CONSULTEE RESPONSE (Council's arboriculturist)

Reference: BE/16/22/PL

Proposal: External alterations to the existing building associated with the change of use from Class E Restaurant to Sui Generis (consisting of a coffee shop / restaurant selling food and drink for consumption on and off the premises), alterations to car park (including the creation of a drive-through lane, reconfiguration of cycle parking, new pedestrian crossings, and the increase in number of car parking spaces), relocation of footpath, removal of 4 x TPO trees (to be replaced), landscaping and associated works. This site is in CIL Zone 4 (Zero Rated) as other development

Location: Arun Retail Park, Shripney Road, Bognor Regis, PO22 9NF

DETAIL 3 :  
PROPOSED NEW PEDESTRIAN LINK THROUGH SITE  
1:125

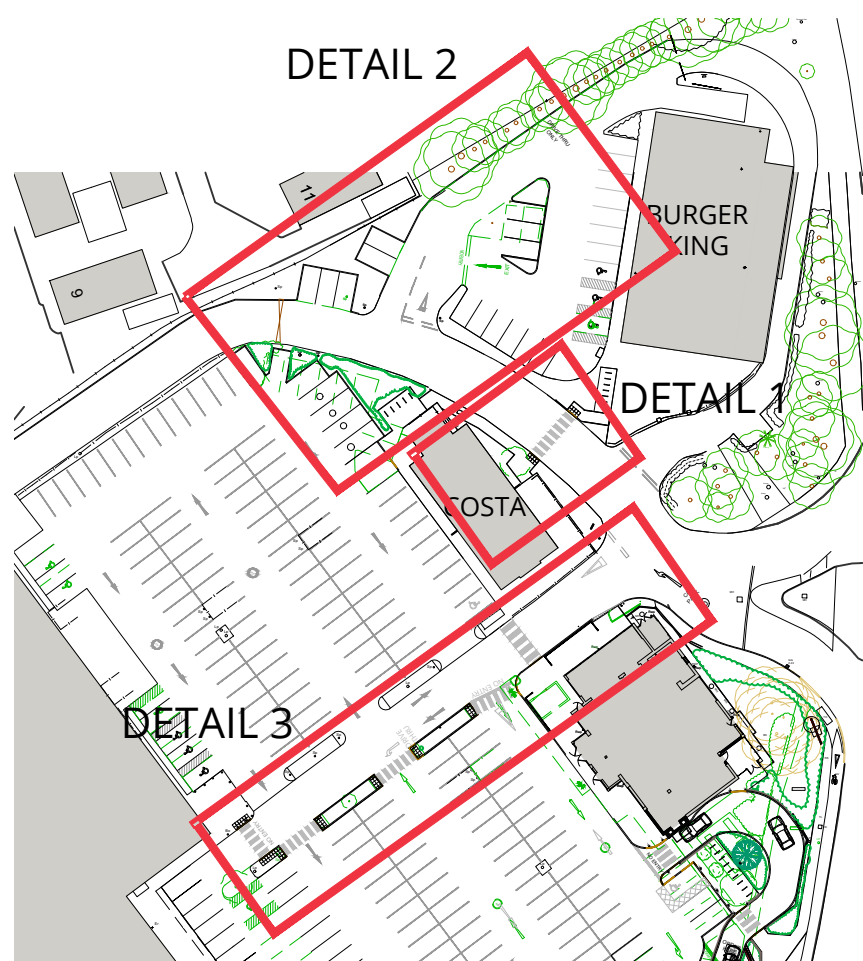
I disagree also with their conclusion that the proposals do not conflict with our Arun Local Plan Policy D DM1. It is clear their proposal would not permit retention of T6 & T7 (category B trees) and so fails to incorporate existing trees as an integral part of development proposals.

While the scheme may have much to commend it, in arboricultural terms the impact is relatively high and so I would like to understand if there is an alternative pedestrian facility that could be provided whilst permitting retention of those trees, or indeed if enhancement of that existing facility is necessary at all.

TREE PROTECTION PLAN (11069 TPP 01 Rev D)

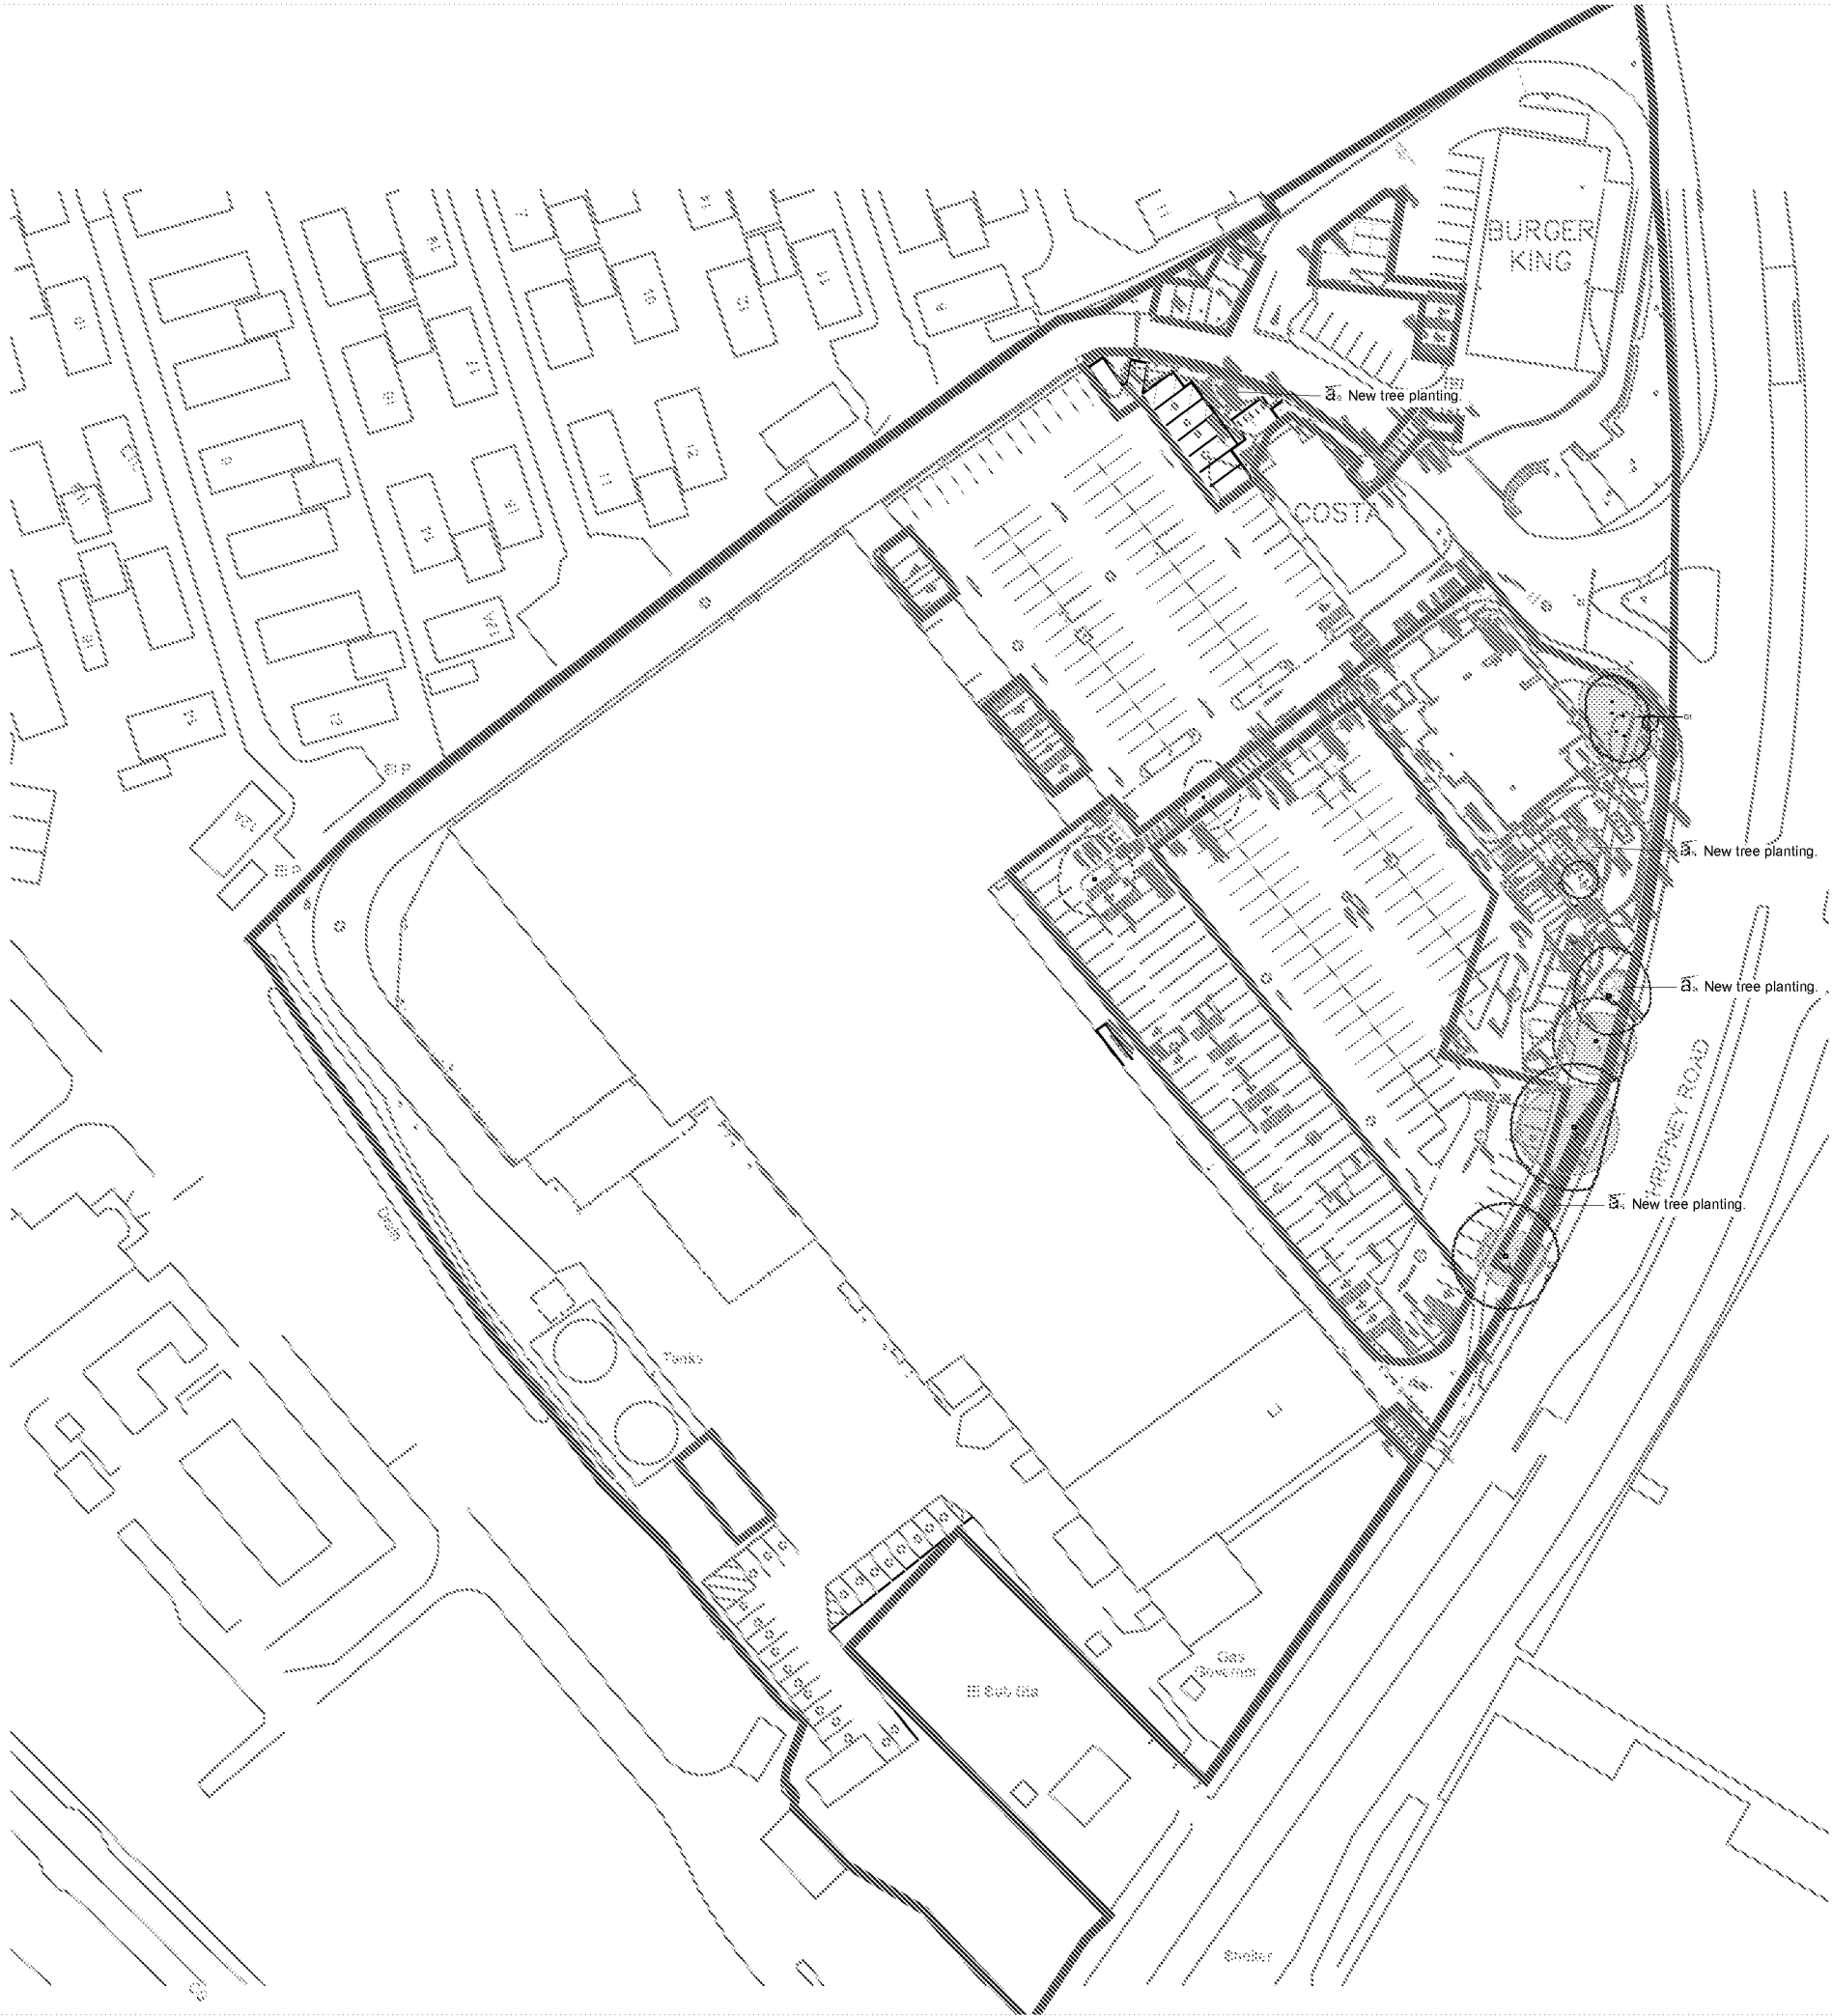
The applicants have employed Aspect Arboriculture Ltd. to prepare an Arboricultural Impact Assessment inclusive of Tree Constraints Plan and a Tree Protection Plan (TPP) for this project, although no supporting Method Statement (AMS) for the latter. It is usual practice to submit an AMS alongside the TPP and I see no obvious reason for them not having done so, nonetheless for this site (were the development proposal to be granted consent) it could be secured by pre-commencement condition.
